TOWN AND COUNTRY PLANNING ACT 1990 TREE WORKS IN A CONSERVATION AREA

Reference: H16-1247-21 **Date of Decision:** 11th January 2022

Location: Spalding Grammar School Priory Road/St Thomas Road Spalding

Description: Works to Trees in Spalding Conservation Area

Spalding Grammar School
Tree safety survey
 16th September 2021

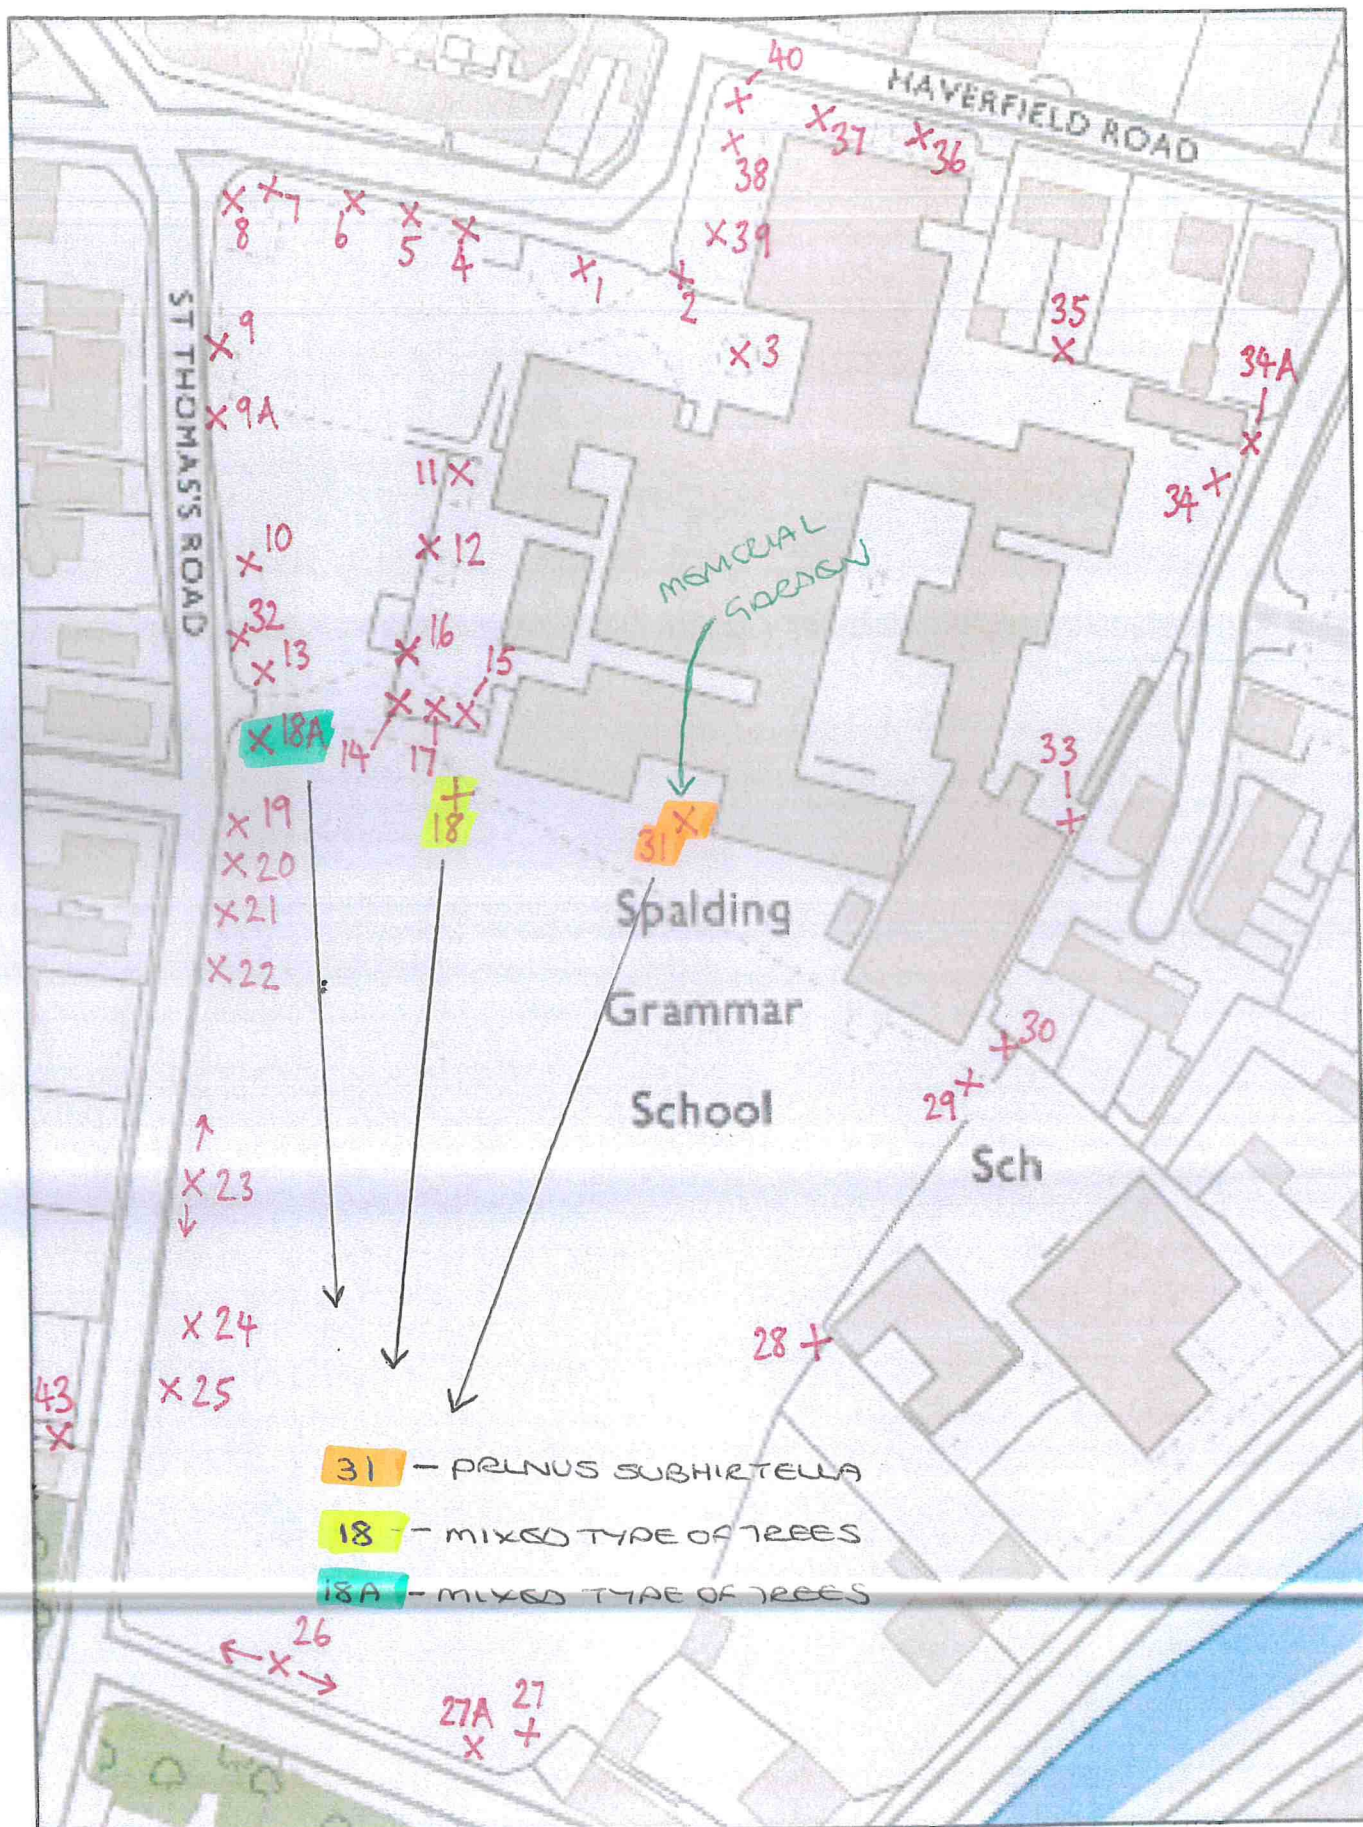
'Species of tree - unknown - Reference No.18 - Tree removal as soon as possible due to root damage caused by suppression from larger trees and trimmer damage. To be replaced with a new tree minimum 1.5 metres. (Health and Safety matter' - Trees and Nature Conservation Officer 'aware). The tree is showing signs of decay from the base and we have genuine concerns for the Health & Safety of our students. Proposed replacement to be confirmed.'

'Unknown - 18a - Tree removal due to root damage caused by fencing construction / suppression from larger trees and trimmer damage. To be replaced with a new tree minimum 1.5 metres. (Health and Safety matter' Trees and Nature Conservation Officer 'aware). -The tree is showing signs of decay from the base and within (rotten internally) we have genuine concerns for the Health & Safety of our students. Proposed replacement to be confirmed.'

'Prunus subhirtella - 31- Tree removal and stump grind following impact from delivery driver. To be replaced with a new tree as advised by' Arboricultural Consultant. '(Awaiting approval - 6 weeks notice 11-01-2022).- Two main branches were recently struck by a delivery driver causing significant trauma to the tree confirmed by' Arboricultural Consultants'. - 'Proposed replacement either a Betula pendula Youngii / Sorbus vilmorinii or an Acer griseum.'

- 1 That the proposed work is carried out within two years of the date of this letter of 'No Objection'.
- 2 Work is to be carried out in accordance with BSI 3998 : 2010, 'Recommendations for Tree Work'.
- 3 The resulting stumps of the trees should be ground out to at least 300mm below ground level, to help reduce the risk of the stumps harbouring decay fungi which could infect nearby trees.

It is recommended that the tree(s) are replaced with: Ref No: 18 - silver birch (*Betula pendula*), rowan (*Sorbus aucuparia*) or whitebeam (*Sorbus aria*); Ref No: 18a - either a silver birch (*Betula pendula*) or species of alder such as *Alnus incana* 'Aurea' and Ref No: 31 - winter flowering cherry (*Prunus subhirtella*) or a paperbark maple (*Acer griseum*) of at least 1.5 metres high on planting, as near as reasonably practicable to the position of the original tree(s), (in this instance trees 18 and 18a in the general vicinity as agreed in the e-mail of 17 December 2021 16:28 from the Trees and Nature Conservation Officer) within twelve months.

The fitting of strimmer deflection guards on the newly planted trees may be relevant on this site, to help prevent repeat damage.
